From: Sue Howell <Sue.Howell@arun.gov.uk>
Sent: 16 December 2019 14:47
To: Planning.Responses <Planning.Responses@arun.gov.uk>
Cc: Michael Eastham <Michael.Eastham@arun.gov.uk>
Subject: FW: Planning Consultation on WA/95/19/DOC

Further comment from Greenspace - Revision to location of proposed golf netting

APPLICATION NO: WA/95/19/DOC

Description of Works: Approval of details reserved by condition imposed under ref
WA/95/18/RES relating to Condition No 5 - golf mitigation

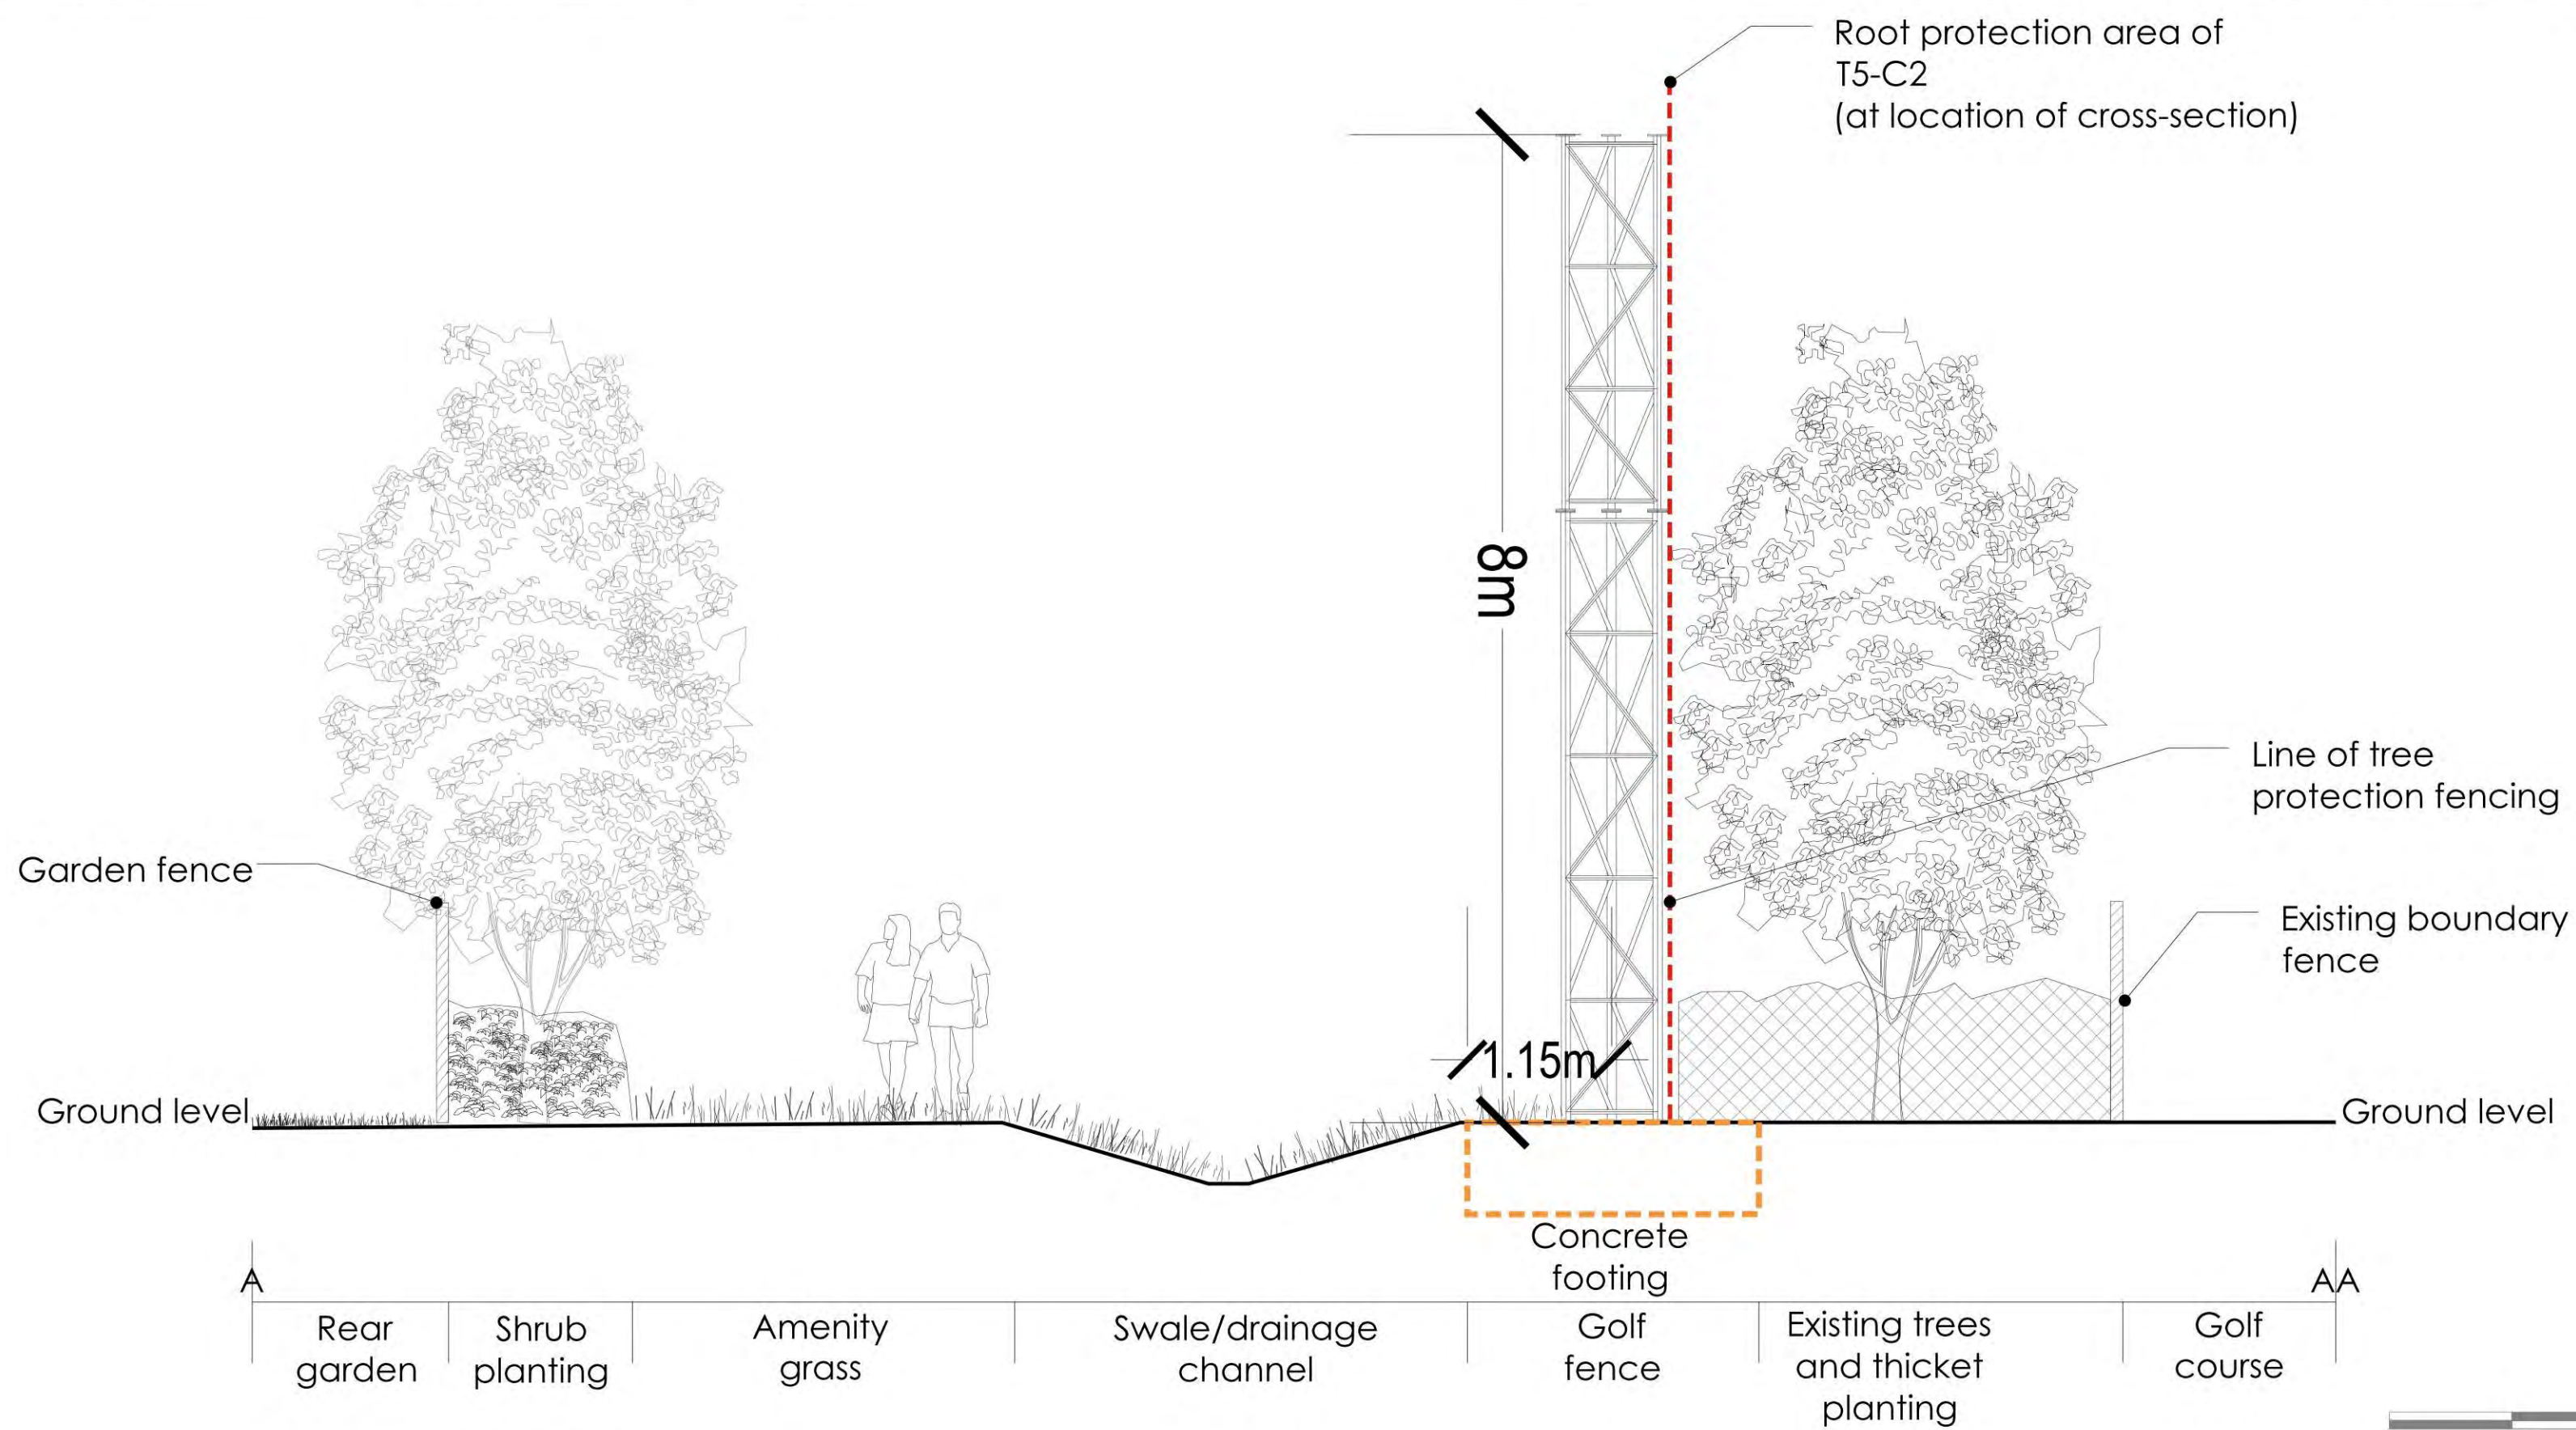
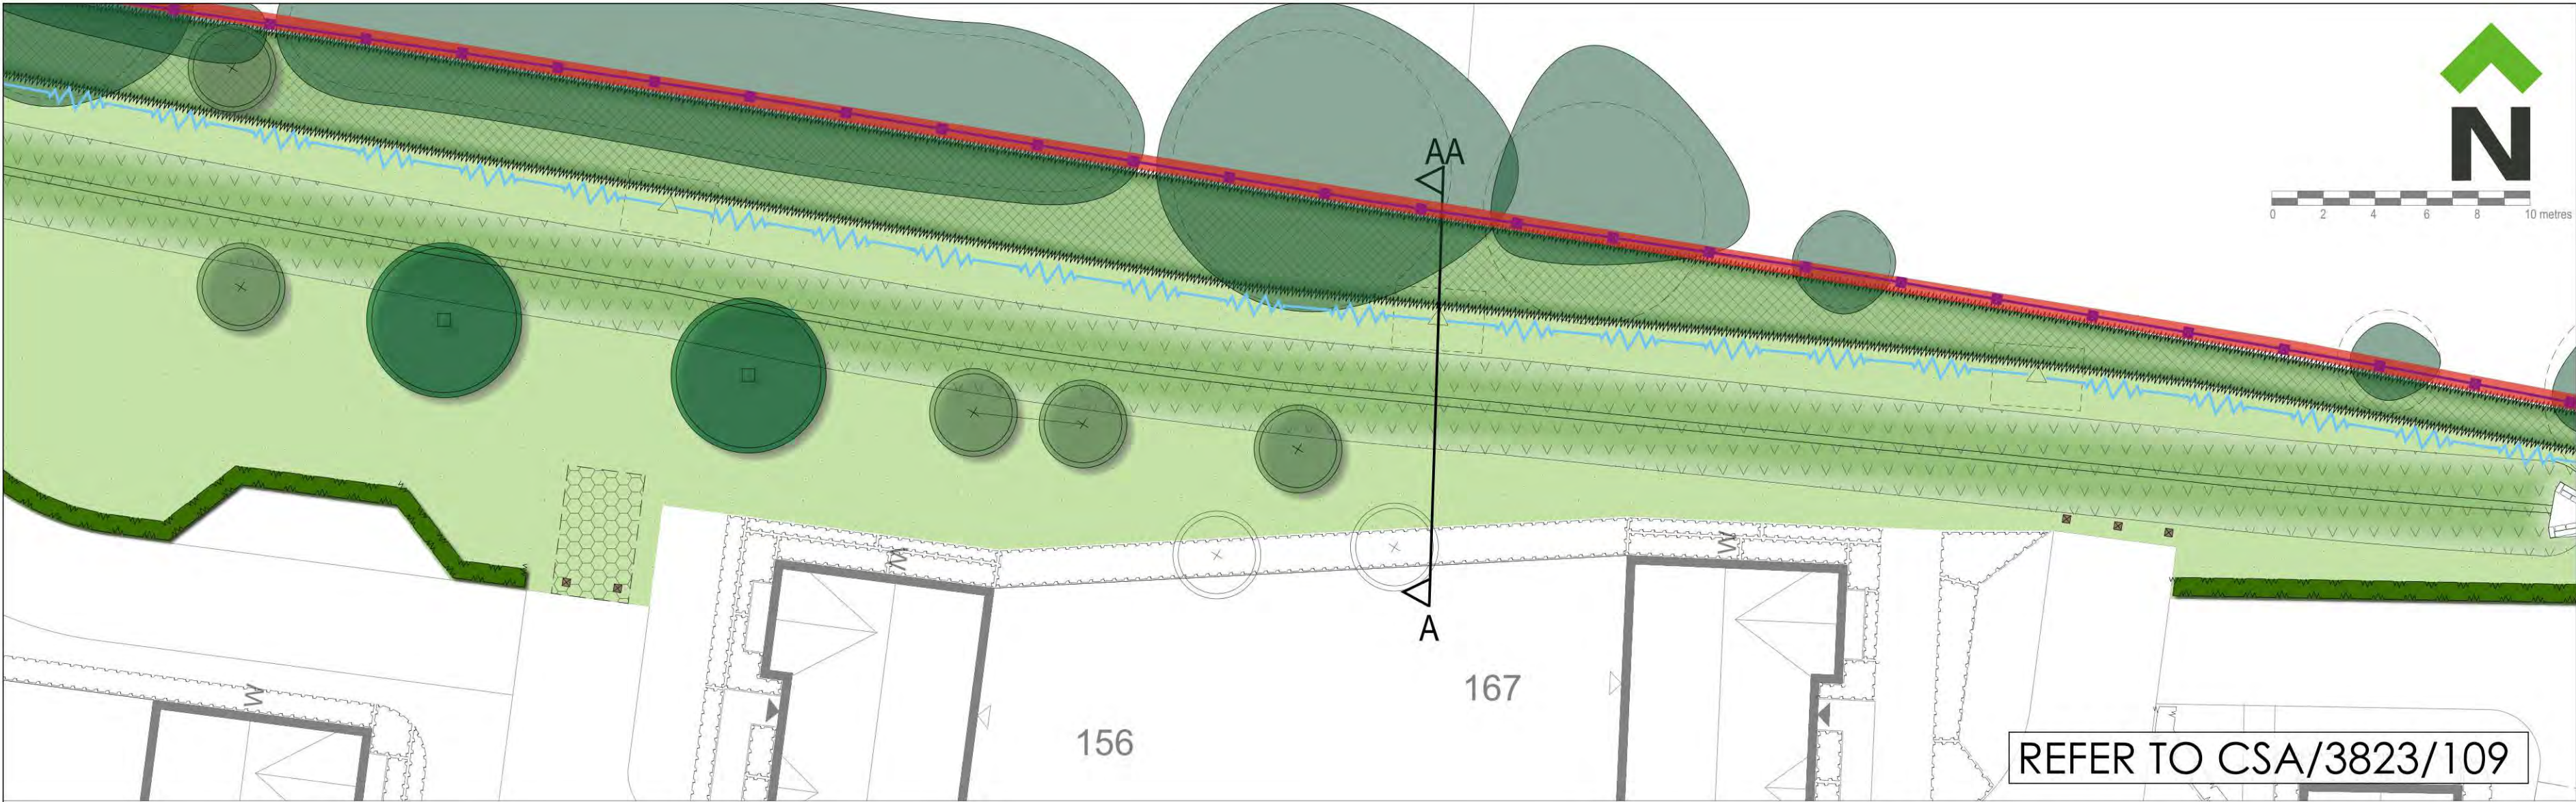
Further to submission of Landscape revision specifically re Golf Course Netting Details and positioning of same and now contained in Dwg Sept 19 GNL.01 Rev C Proposed Golf netting Location now staggered and location **and in consideration of swale location**, amended and CSA/3823/119 and associated Soft landscape proposals dwgs CSA/3823 101-103 **REV G, G & J** CSA/2823/107-110 I can confirm that the information supplied proposes a scheme for the purpose of offsetting any on-site or offsite mitigation measures to minimise the ingress of golf balls onto the site, along with a landscape proposal which over time should minimise the visual impact of these measures. The thicket planting is to be planted golf course side of the development, but as this establishes it will be seen through the netting and form a green screen of varying height and thickness.

The detail of the ball stop netting adjacent to the golf course, has a planting proposal which whilst would not disguise it, will go somewhere over time to softening the impact of this –however not to the full height 10m of the fencing proposed. I confirm that I would see a visual improvement in the staggering of the fencing now 6-10 metres The visual impact of these measures along this boundary should be noted. There has been the inclusion of mature tree planting in this location which has a greater opportunity as it establishes to detract the eye, whilst allowing important views through to the golf course beyond.

The fencing will need to be maintained in good condition thereafter in order for the purpose of this to be realised.
